DeLUCA-HOFFMAN ASSOCIATES, INC.
CONSULTING ENGINEERS

**Subject: Convenience Store and Fuel Station Development
2282 Congress Street
Final Site Plan Application
Response to Preliminary Review Comments Dated April 10, 2013**

**FIRE TRUCK**      feet

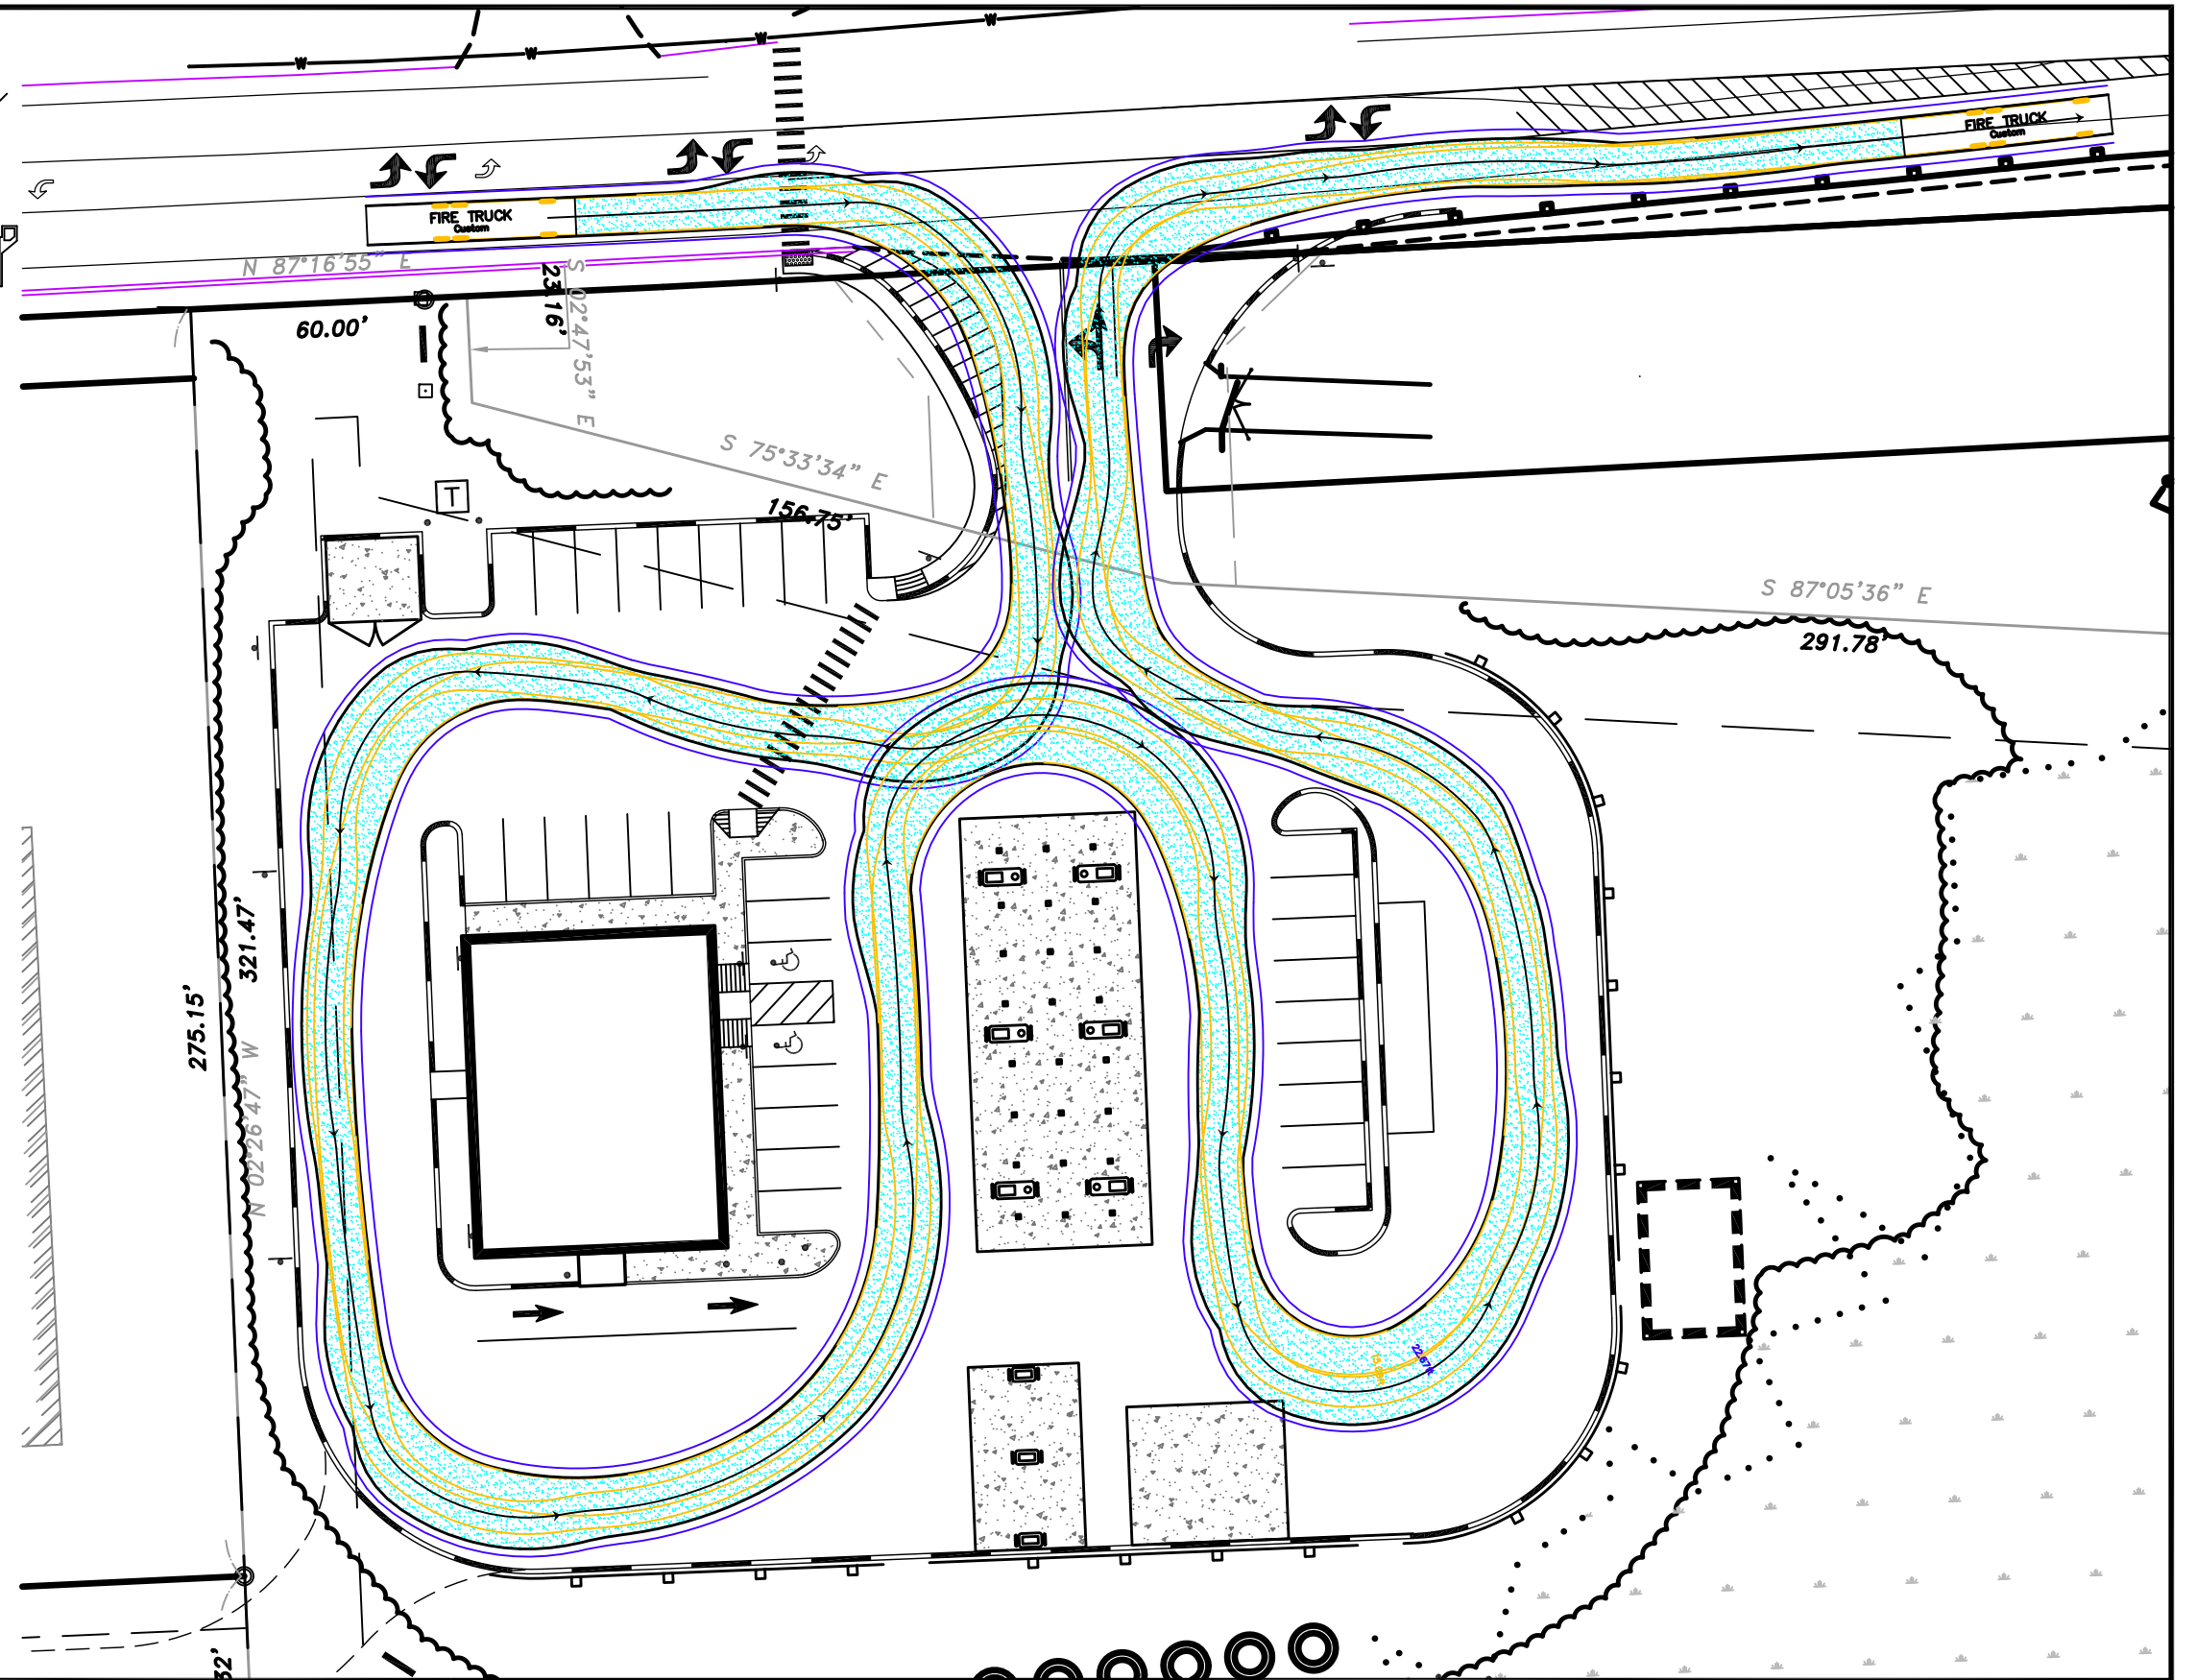
Fire Department issues: You have outlined in a letter dated April 1 to Captain Chris Pirone how the project addresses Fire Department issues and I suggest you contact him asap to further clarify the proposals so he can determine whether the site plan is satisfactory.

Our office has prepared the enclosed figure which shows a fire truck maneuvering around the site. Captain Pirone has verbally outlined the following related to the Fire Department review:

1. State Fire Marshall approval is required.
2. Access routes shall be a minimum of 20' wide.
3. The fuel canopy overhang clearance shall be at least 13'-1". We are providing a clearance of 14'-6".
4. There shall be a fire hydrant in close proximity to the site. The nearest hydrant is on Congress Street and is located directly opposite the site's northwest corner. The hydrant is located approximately 270' from the building.
5. The building does not require a sprinkler system nor is one proposed.

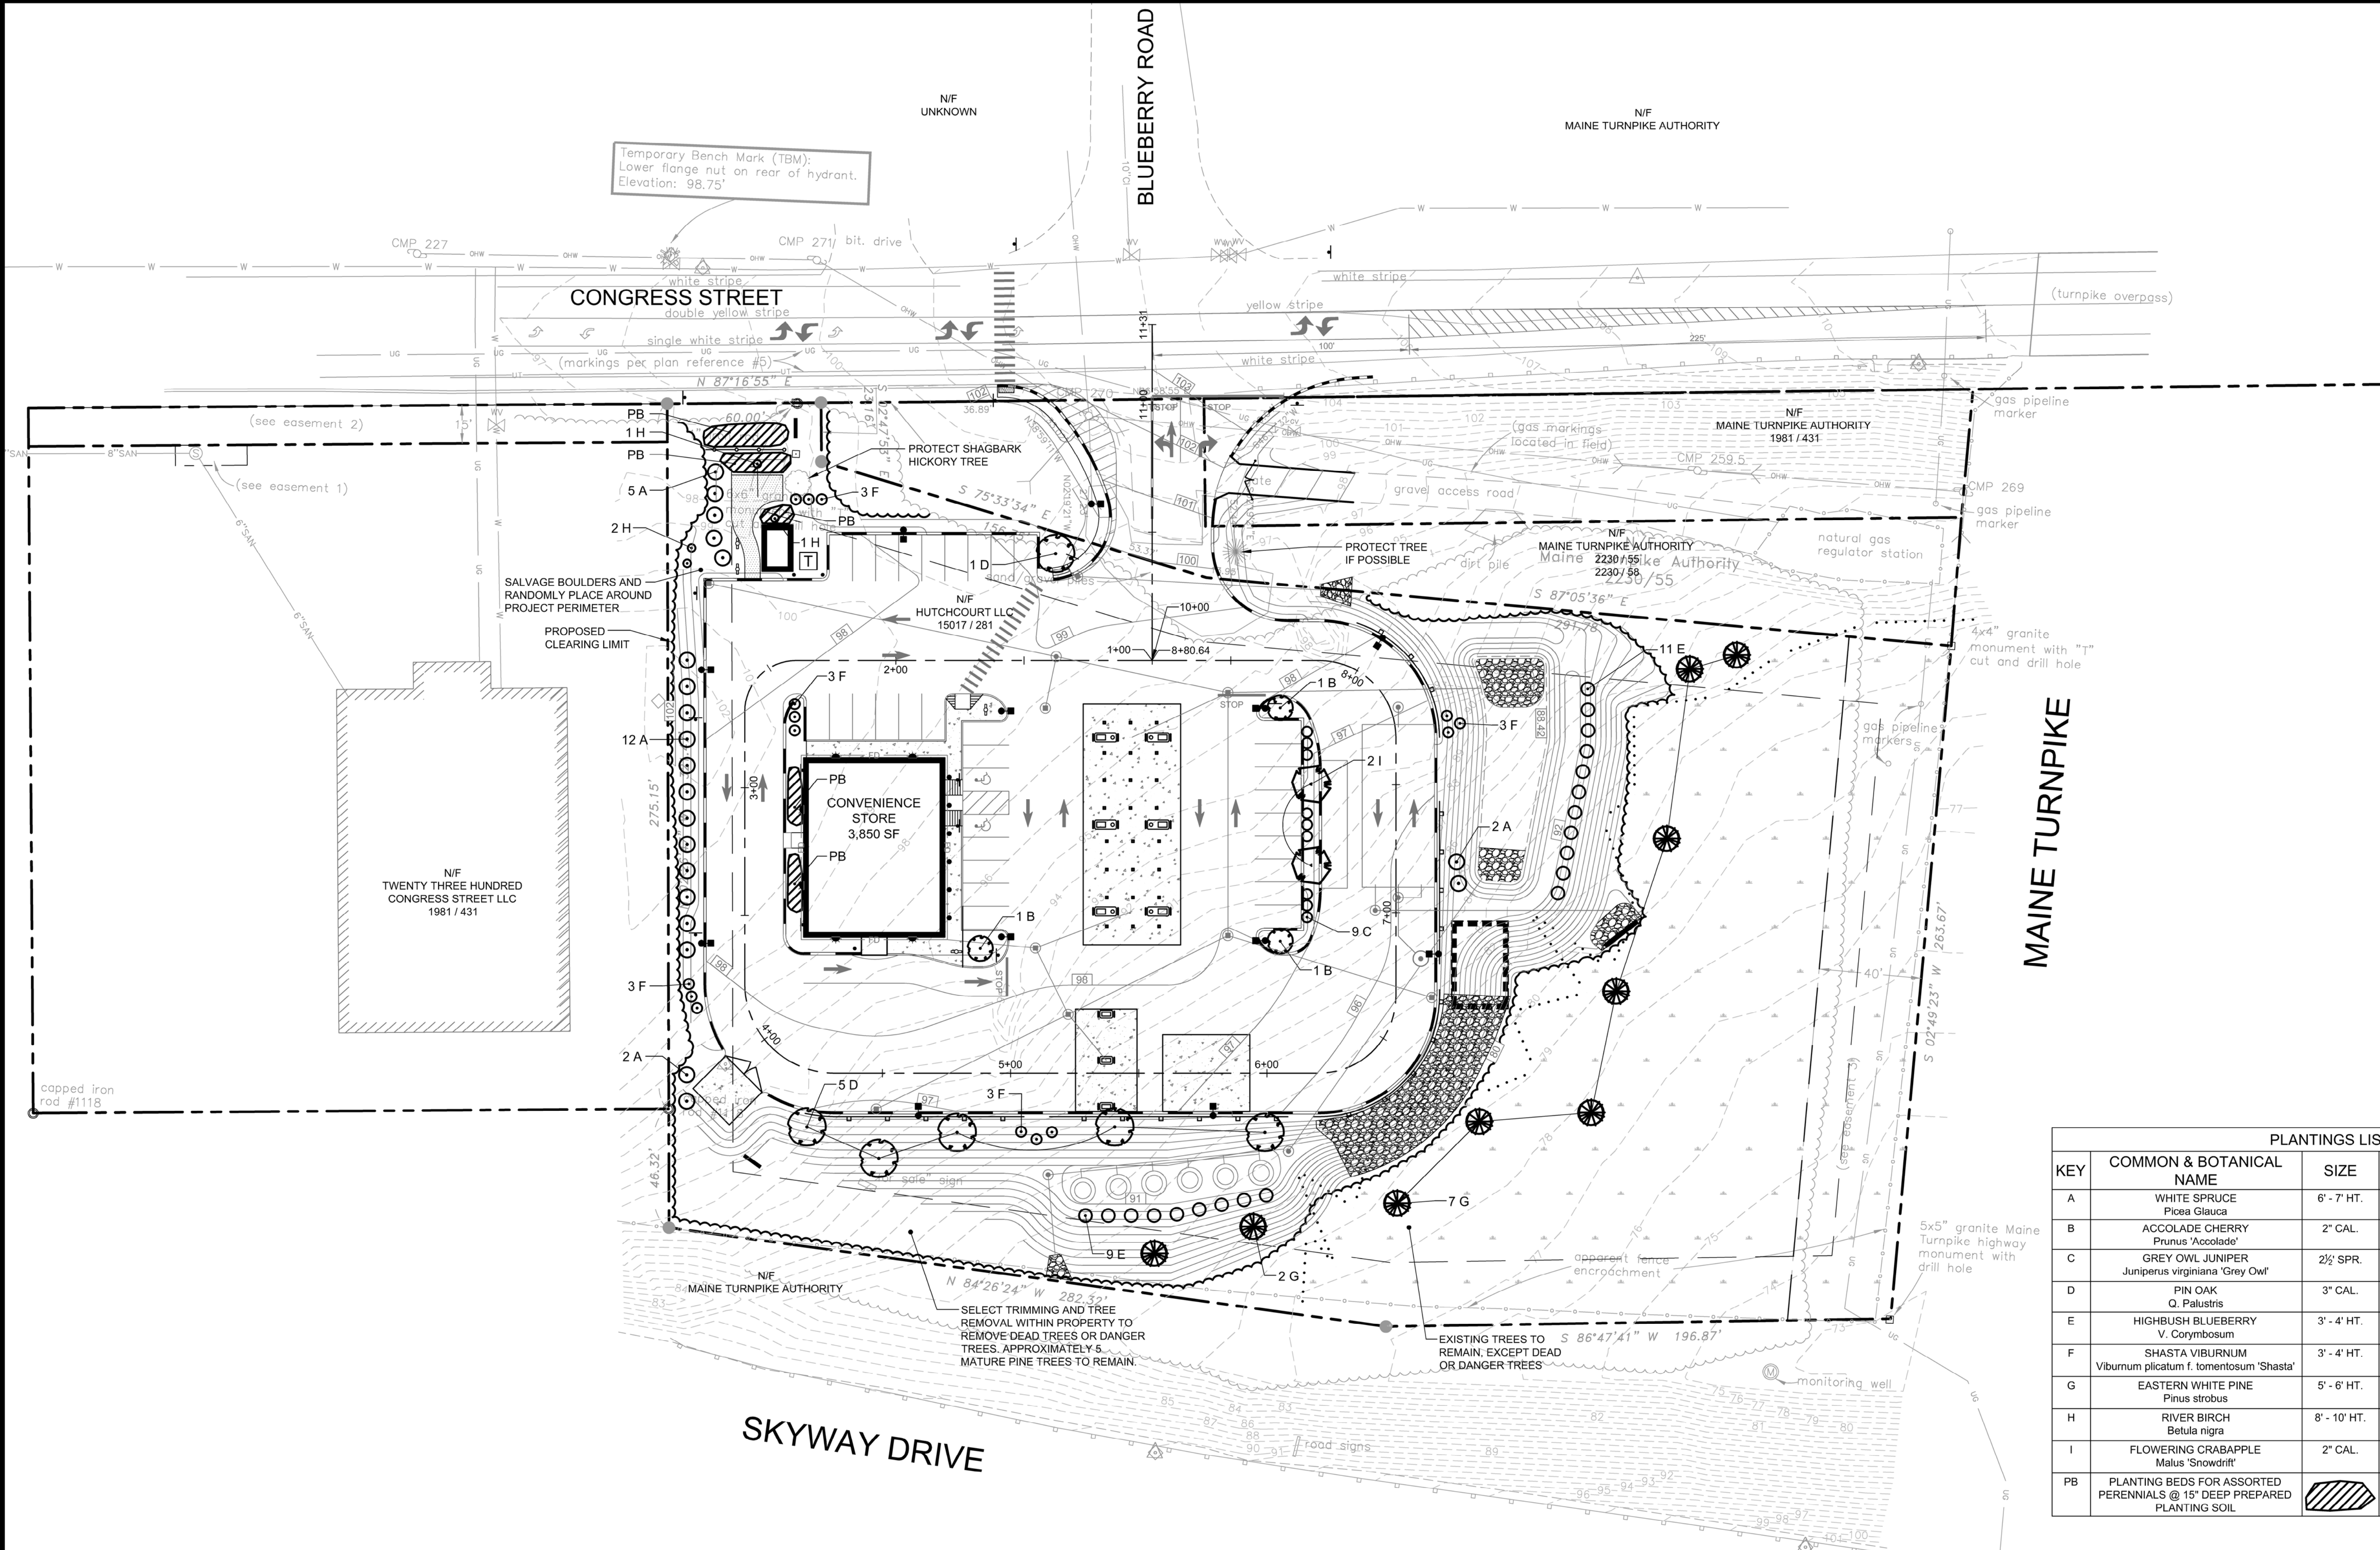
The project needs to include a greater number of trees around the parking lot to meet the parking lot landscape standard (in site plan ordinance) and the CZA objectives re campus like character. The City Arborist (Jeff Tarling at JST@portlandmaine.gov - 874 8820) has noted several areas where trees may be able to be planted, but before making suggestions he would like to discuss with the applicant.

The Landscape Plan has been modified to include additional plantings per our discussion with Mr. Tarling. We also note the addition of a small (12’x18’) wood framed accessory building that is planned for use as a seasonal farm stand. The applicant is seeking to encourage local farmers to use the stand for the display and sale of farm products and related products.
